RE: M-51 Industrial– Response to City Comments

Please refer to our responses below which address all review comments received from the City of Marysville on September 1, 2023, regarding the M-51 Industrial submittal package. You will find the markup comments listed in the order that they were written followed by our response in *italics*.

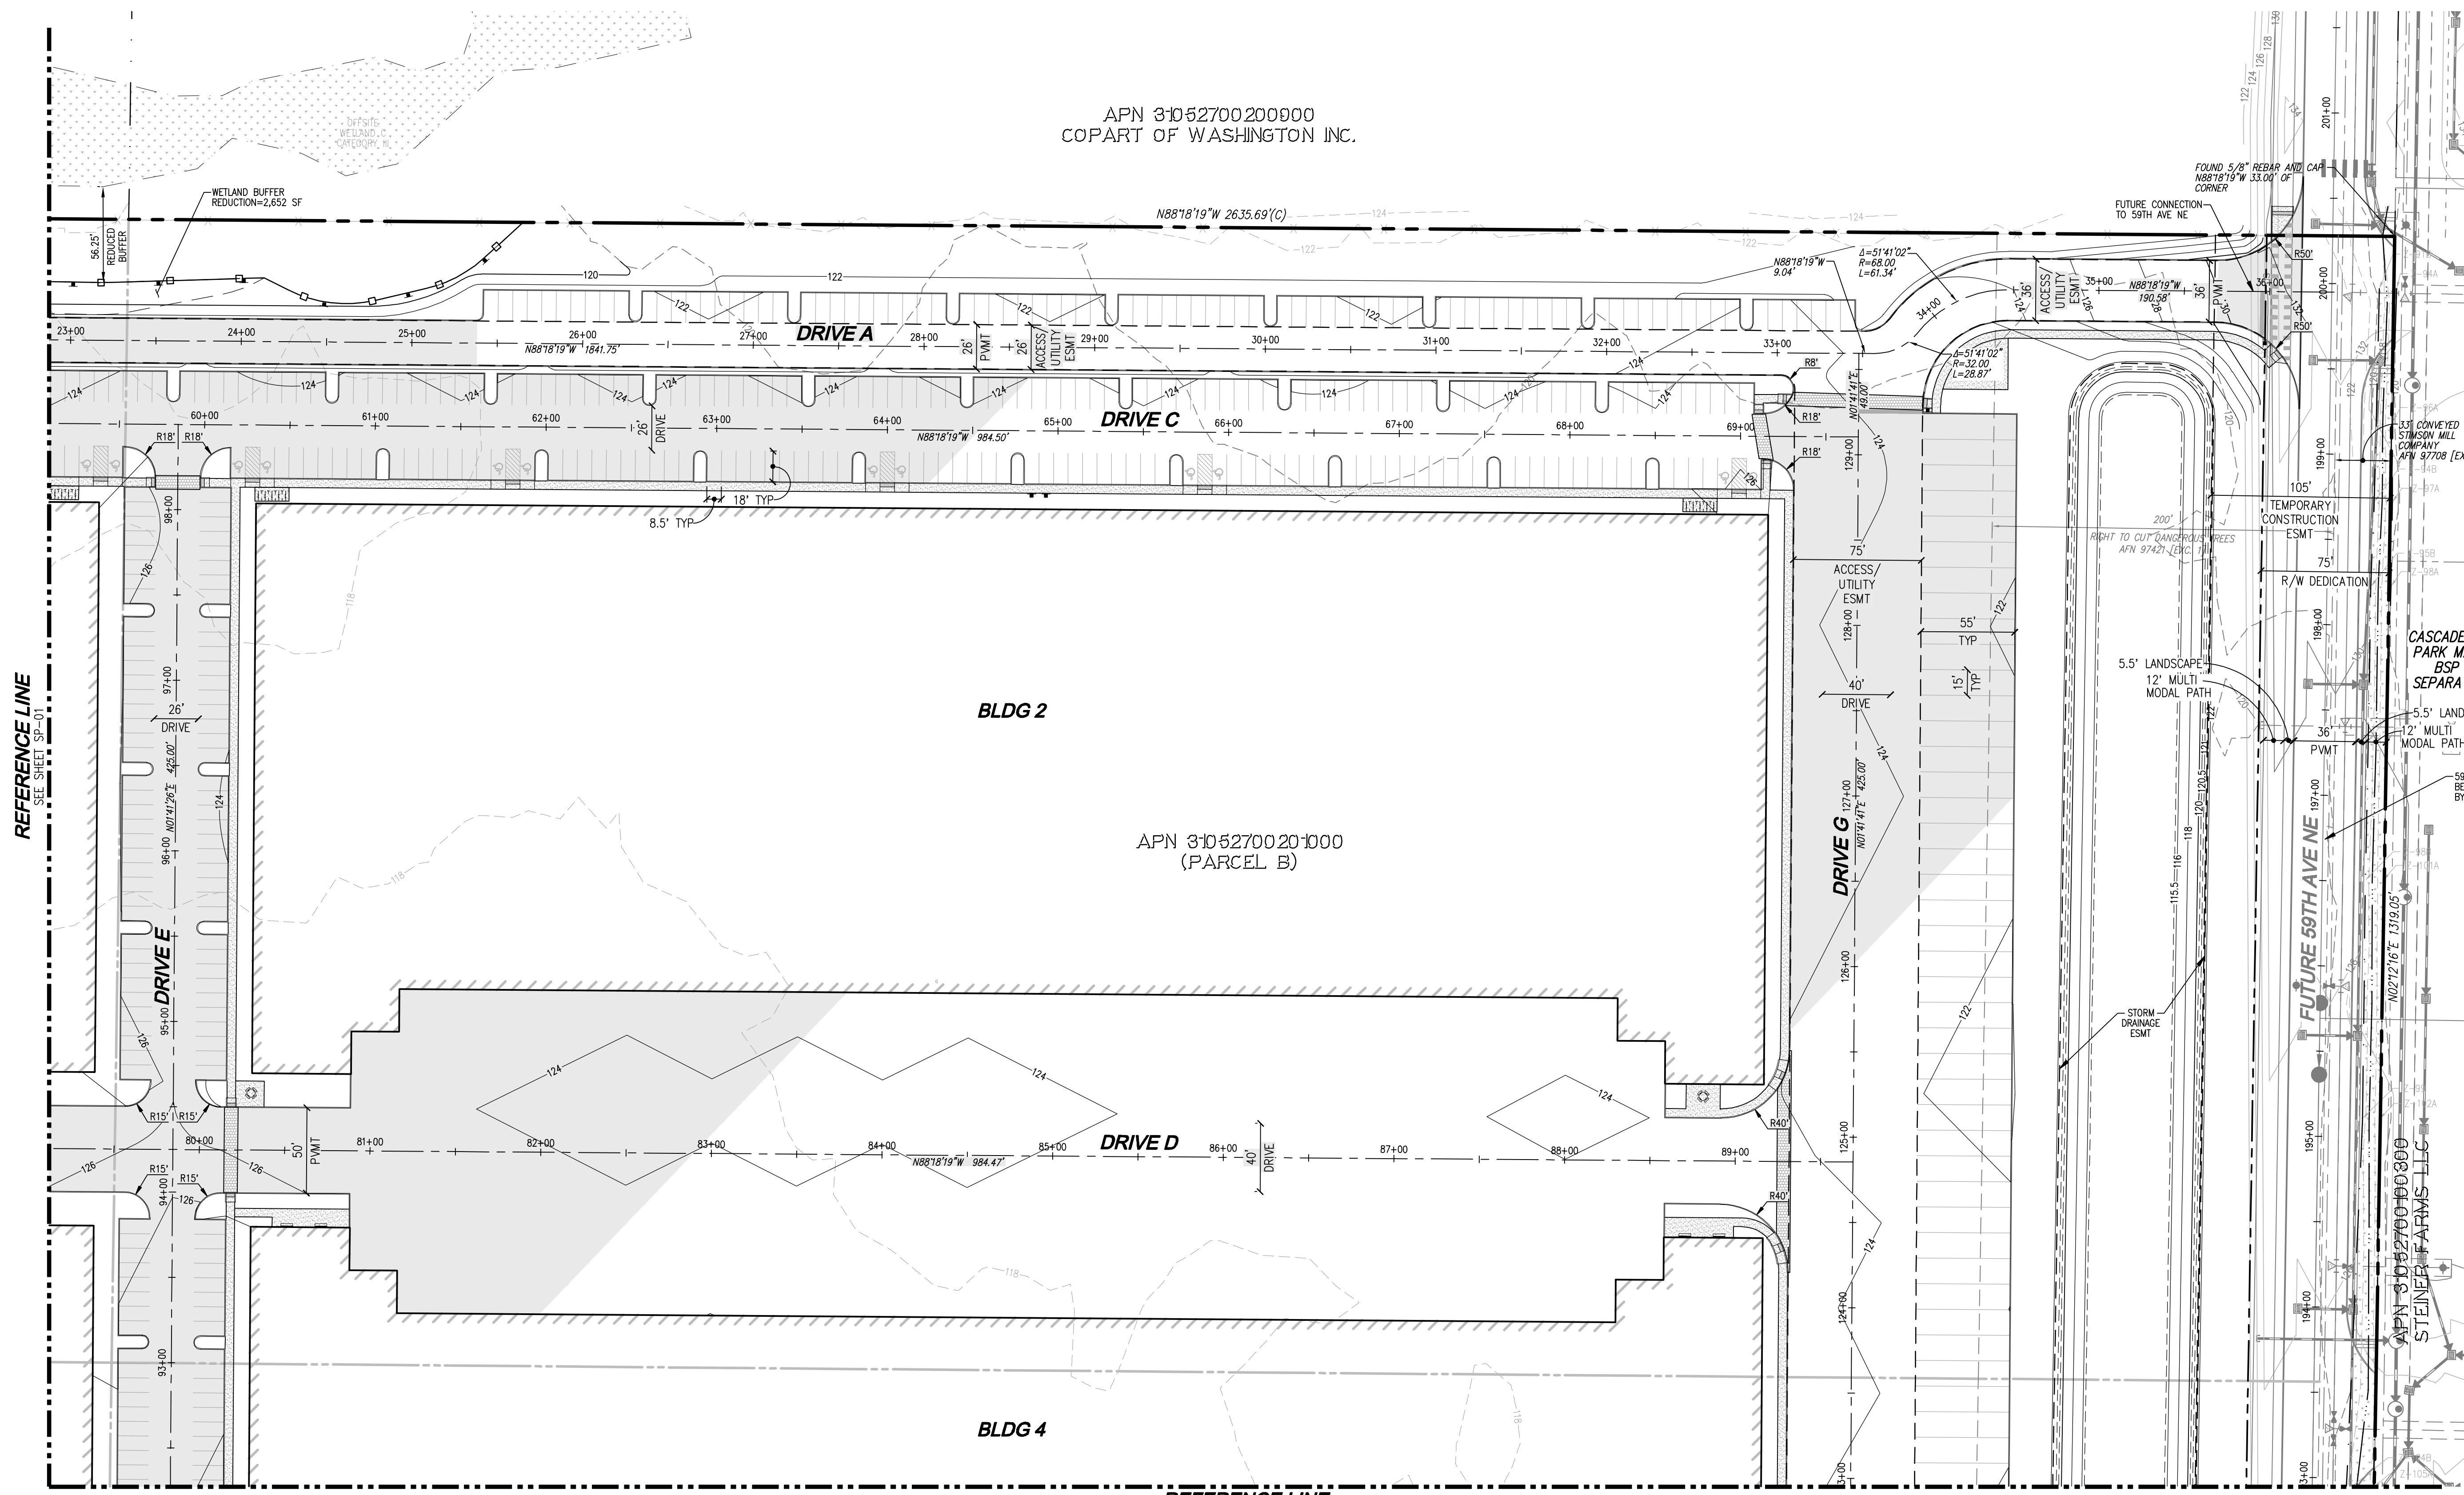
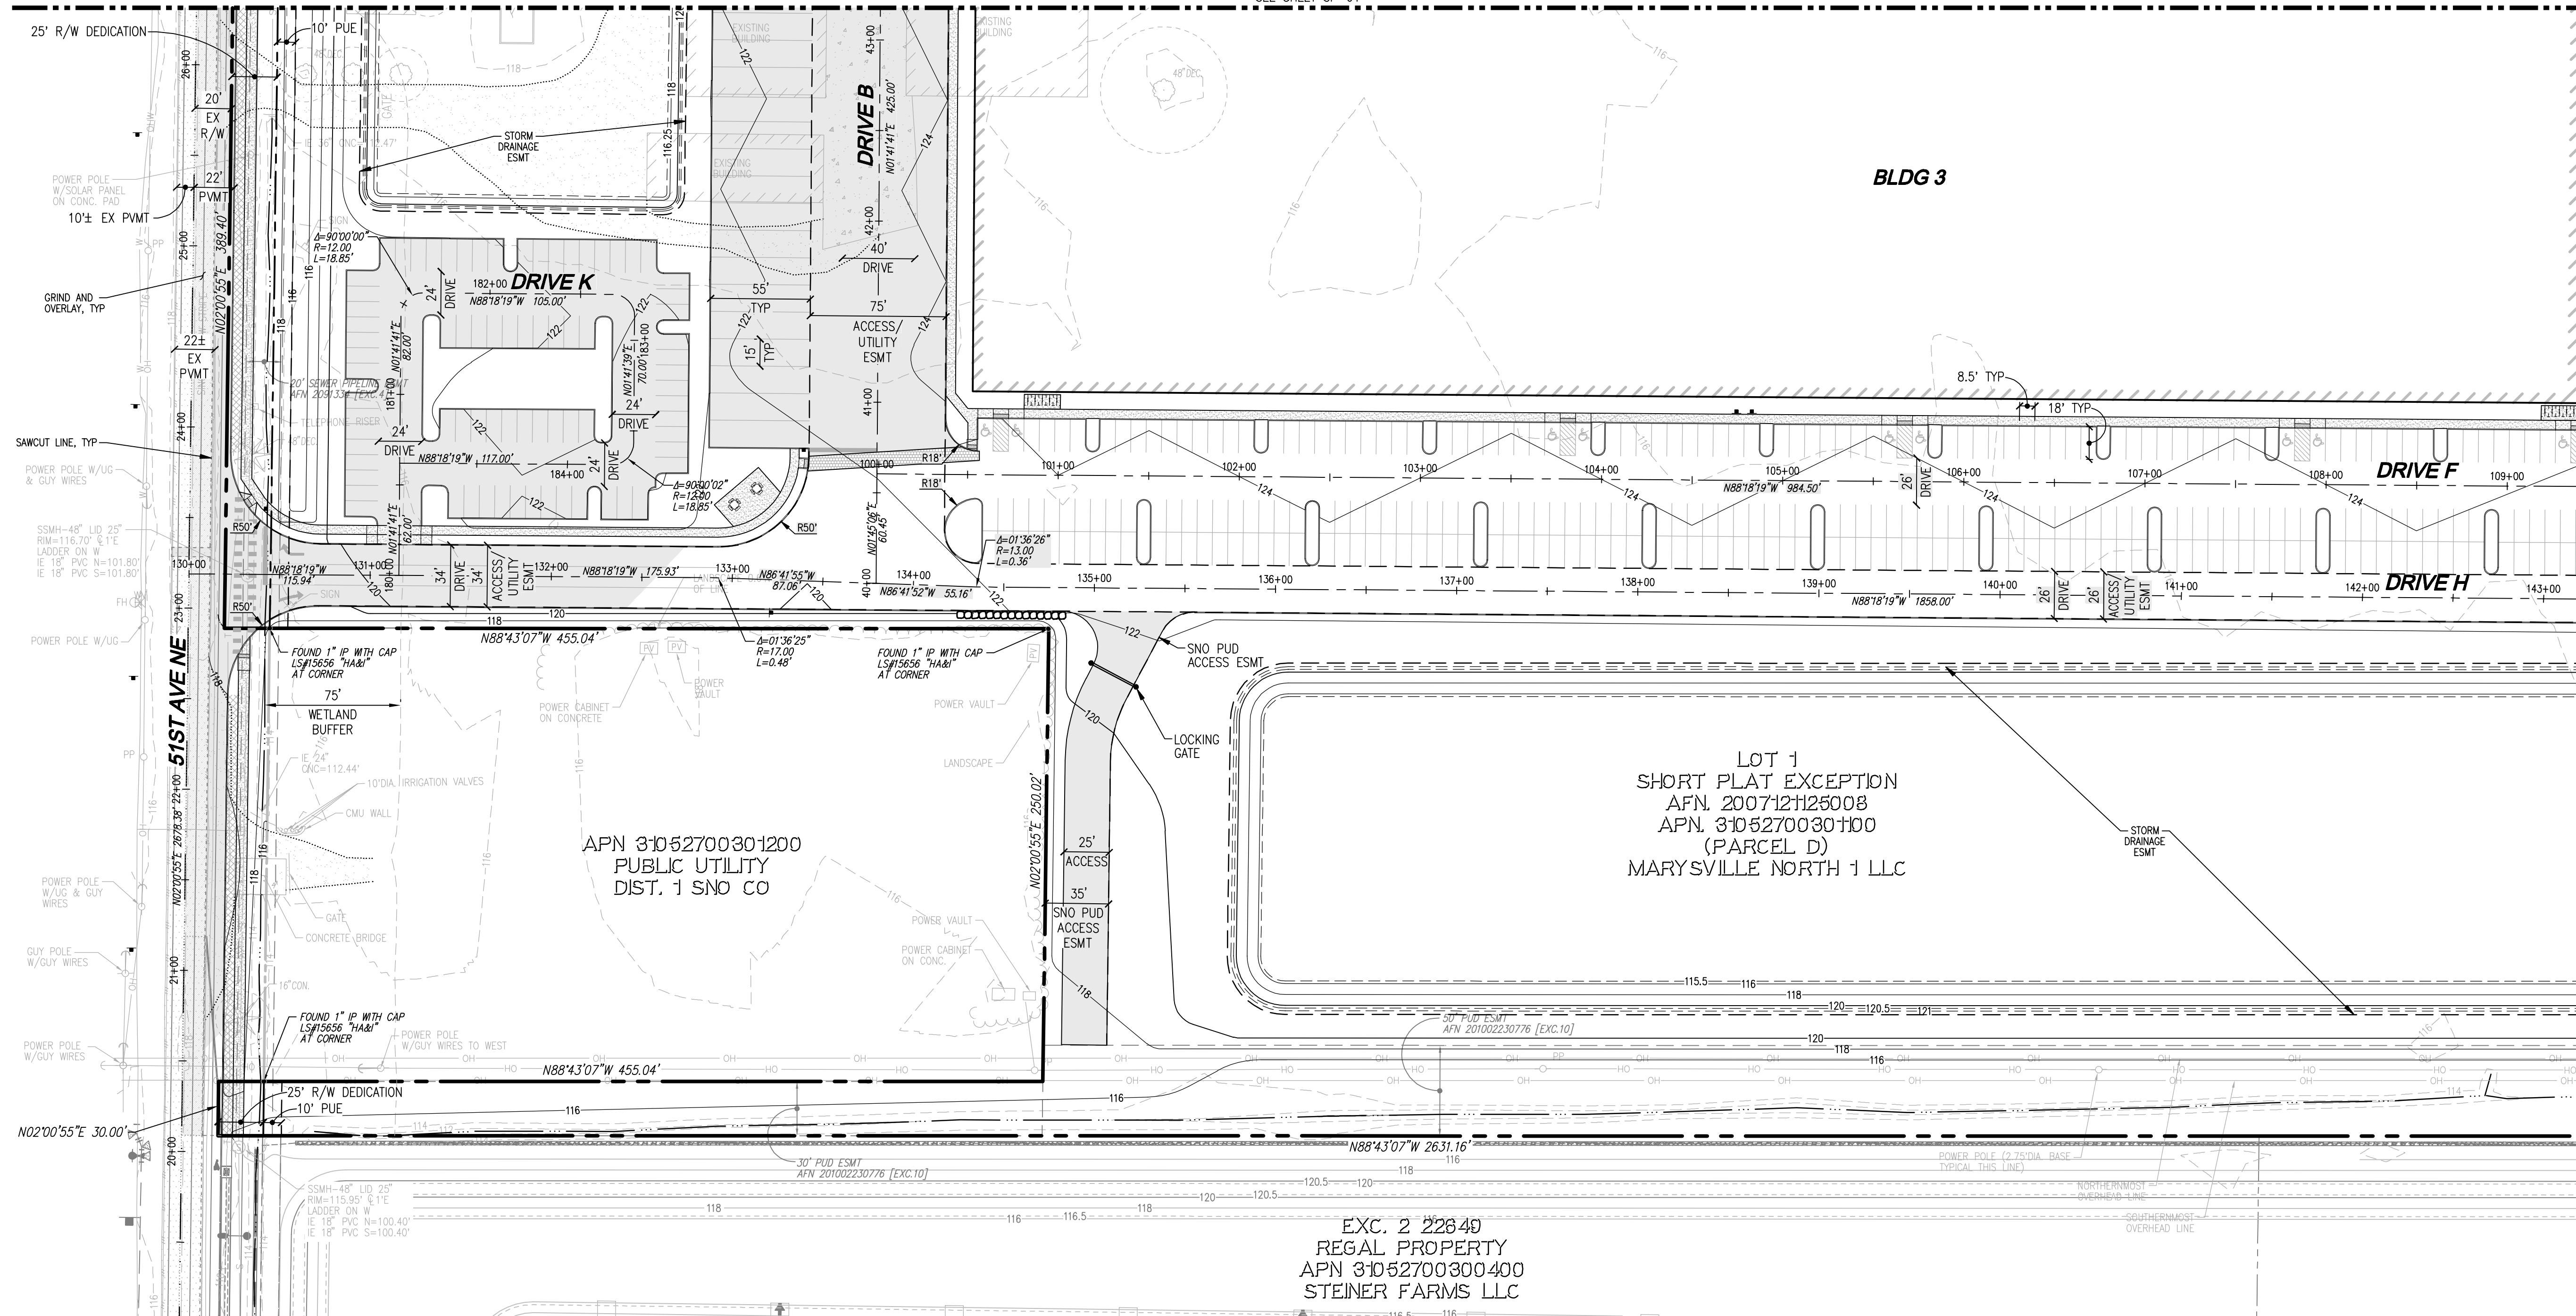
2. See attached comments from Snohomish County PUD related to access to the existing power lines.
Response: Noted.
- Site Plan Edits:
3. Pedestrian connections shall be provided from 51st Avenue NE and 59th Avenue NE and the building entrances. Pedestrian pathways that traverse a parking area or drive-aisle shall be constructed with decorative concrete.

Response: Revised site plan with the pedestrian access from 51st Ave NE and 59th Ave NE as noted.
 4. Parking areas shall include a landscape island every 10 stalls. The landscape islands shall be a minimum of 5' in width and 120 SF in size.

6. The standard parking stalls shall measure 8.5' x 18'.
Response: Revised plan set with above noted dimensions.
 7. Provide off-street parking calculations, including standard ADA, carpool and bicycle demonstrating compliance with the MMC.

Response: Added off-street parking calculations.
 8. Five spaces or five percent of the parking spaces on site, whichever is less, must be reserved for carpool use before 9:00 a.m. on weekdays. More spaces may be reserved, but they are not required.

Response: Revised site plan with carpool parking and above note.
 9. Carpool spaces will be those closest to the building entrance or elevator, but not closer than the spaces for disabled parking and those signed for exclusive customer use.

11. Bicycle parking shall be provided at a rate of 5% of the number of required off-street auto parking spaces. Design and location shall be provided in accordance with MMC 22C.130.060.

12. Provide location of required ADA parking spaces.

13. Provide location of required carpool parking.

14. Provide location of required bicycle parking.
